Re: O'Reilly Auto Parts Store
2417 Marksheffel Road
Colorado Springs, CO #11 (C11)
Project Number: PPR 202

The following are in response to comments from Mountain View Electric Association, Inc., dated January 16, 2020.

Re: O'Reilly Auto Parts, Site Plan
2417 Marksheffel Road
Colorado Springs, CO (C11)
Project Number: PPR 202

RE: Colorado Springs, CO #11 (C11) Mountain View Electric Association, Inc. Comments

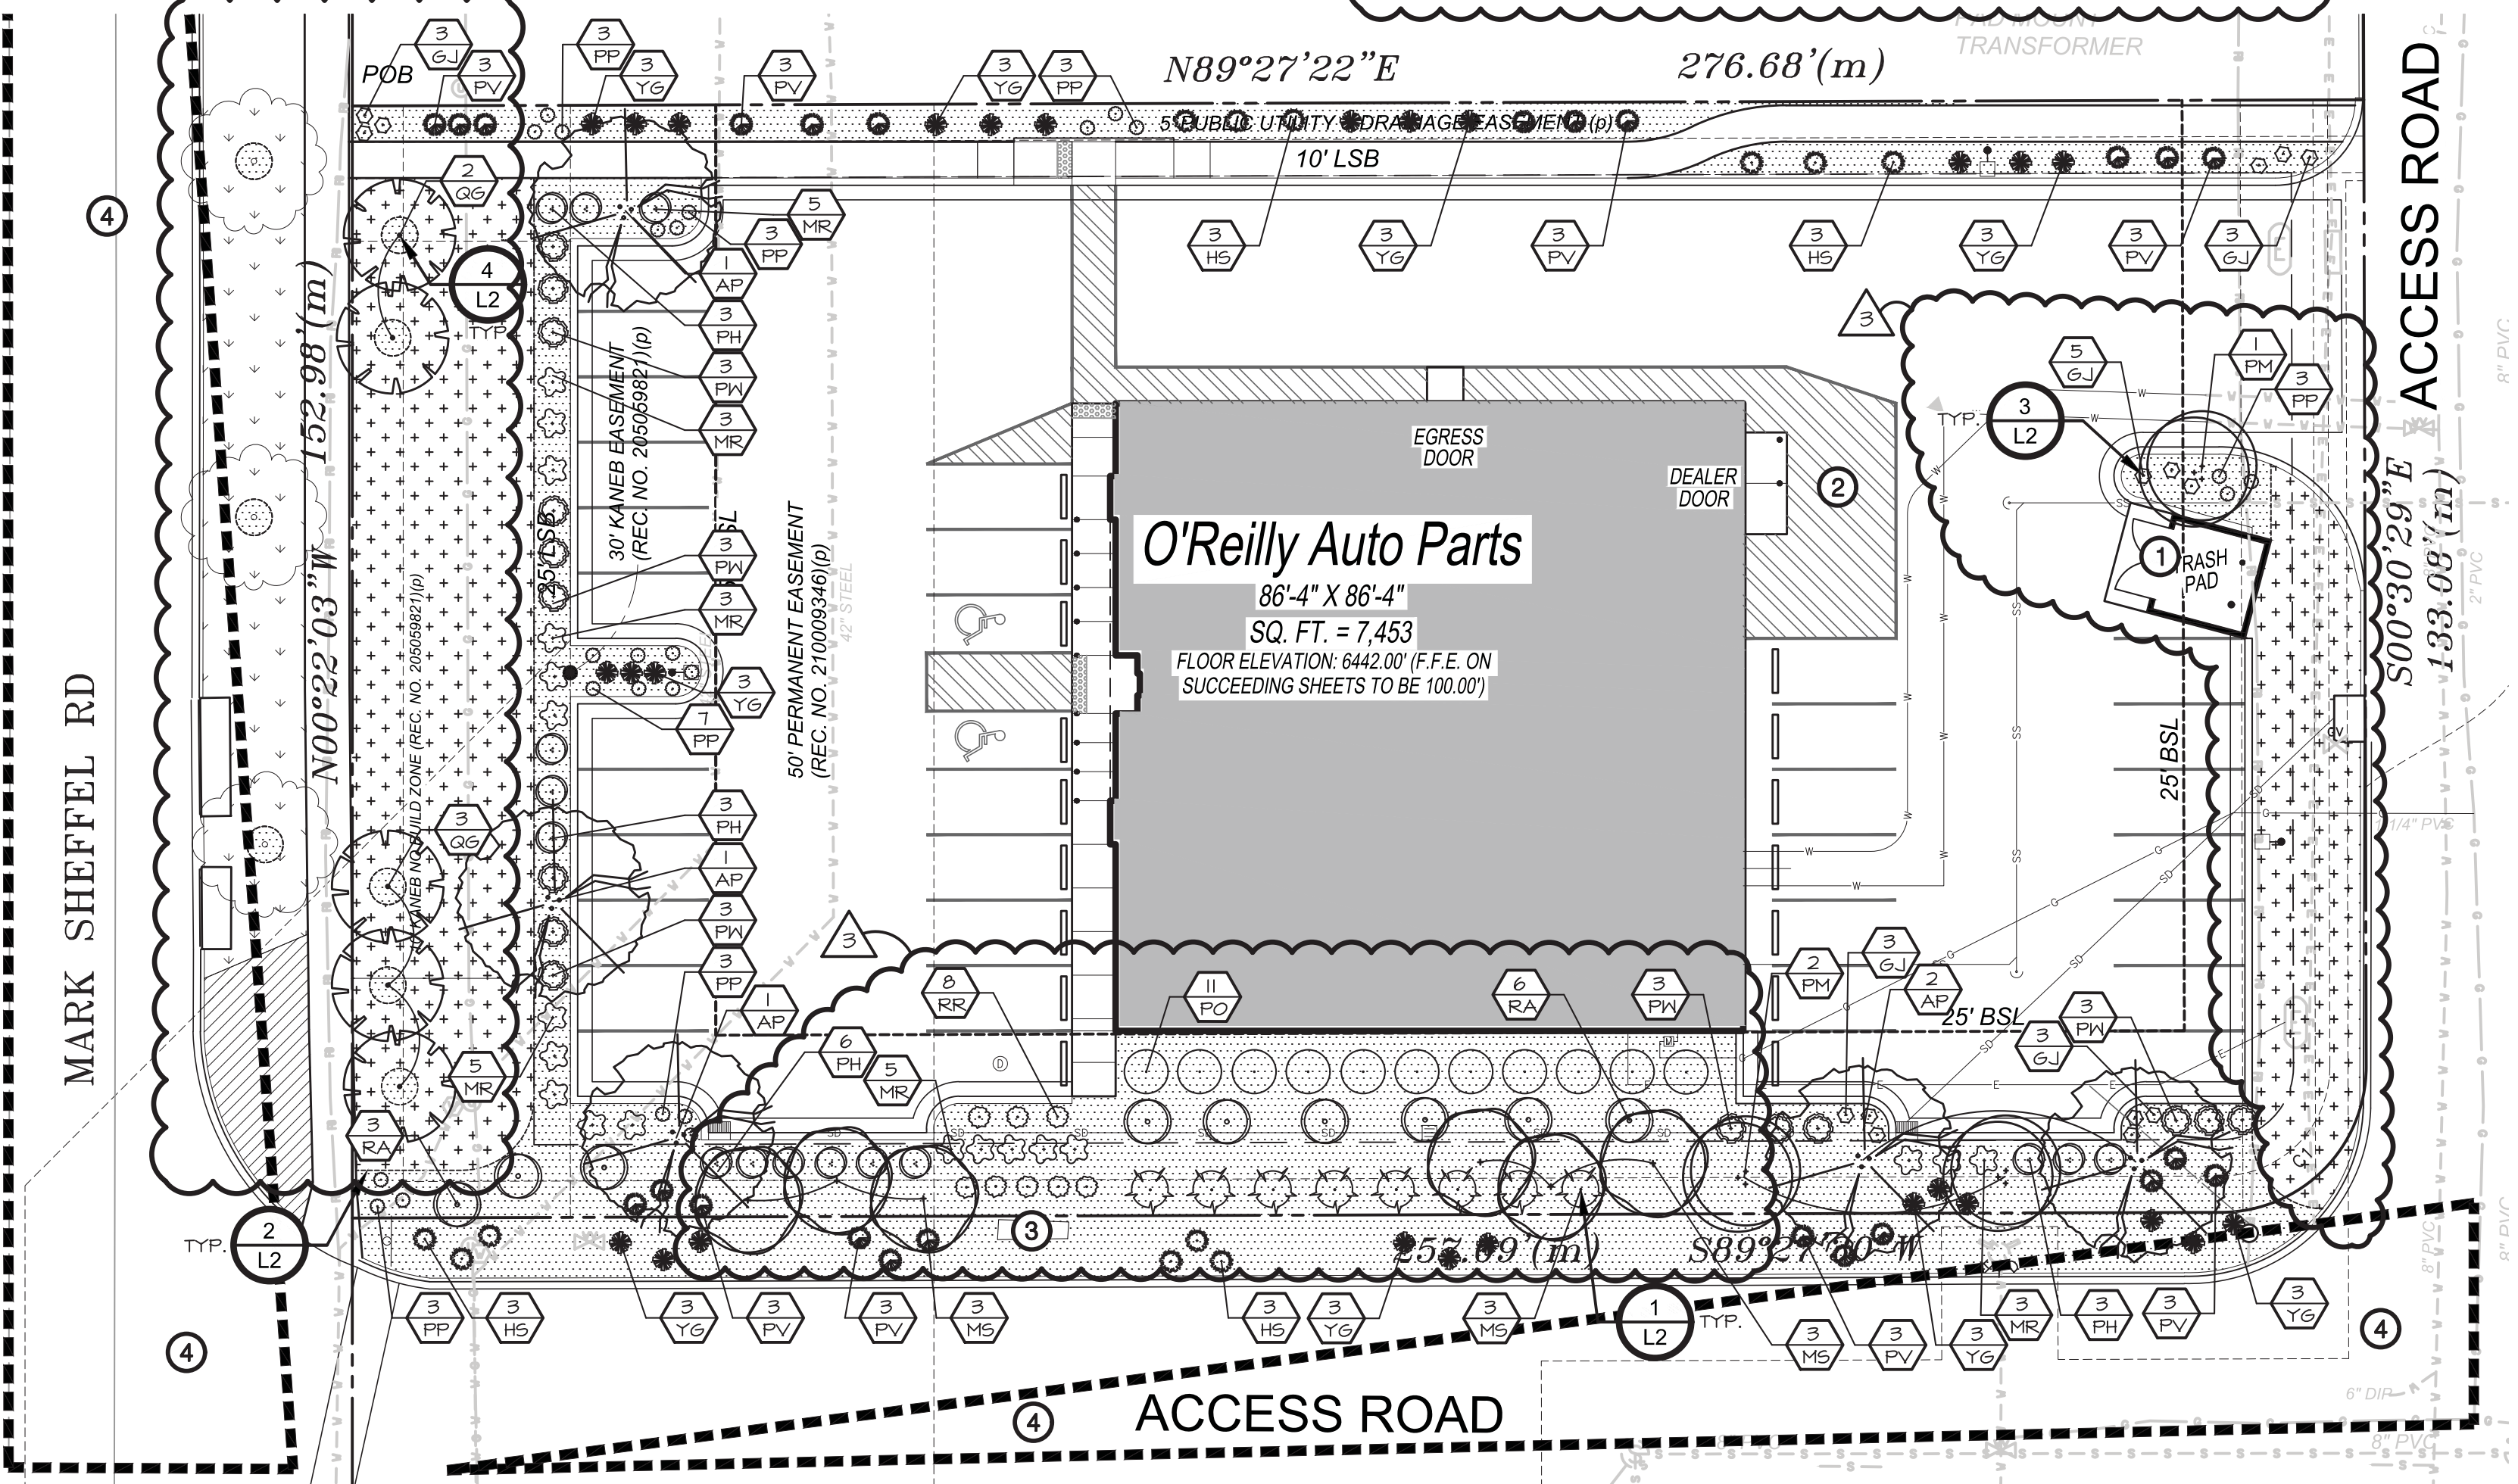
Comment: MVEA has existing facilities within this parcel of land. If there is any removal or relocation of facilities it will be at the expense of the applicant. MVEA requests no trees or shrubs be planted, or placing of sound barrier walls/fences within ten (10) feet of any existing or newly constructed electrical facilities.

Sheet L1

1. Trees and shrubs have been removed along east access road per 10' electrical utility easement requirement.
